REF: 22/01470/F

**Location: OS Parcel 5018 North Of The Gate Hangs High
Inn Hook Norton Road Sibford Ferris**

PROPOSED BUND  
SCALE 1:1 AT A4

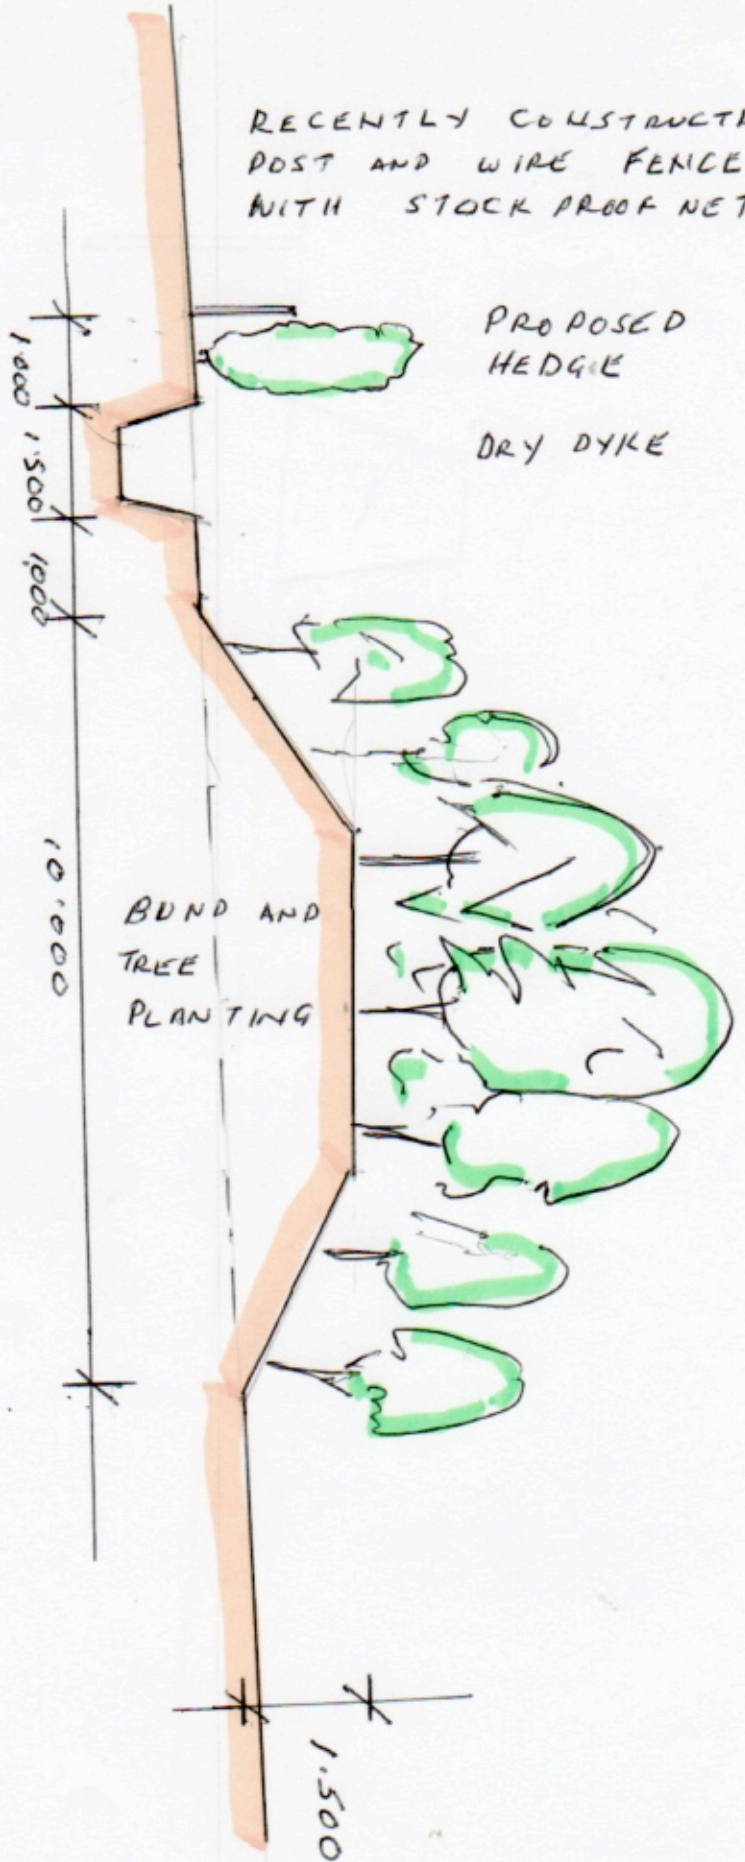
- The depth of the ditch is not indicated within the drawing, I recommend this to be a depth of 1m.
- I recommend interspersing tree planting on the bund with mature shrubs of the same type as the hedgerow planting to create an established boundary from the outset.
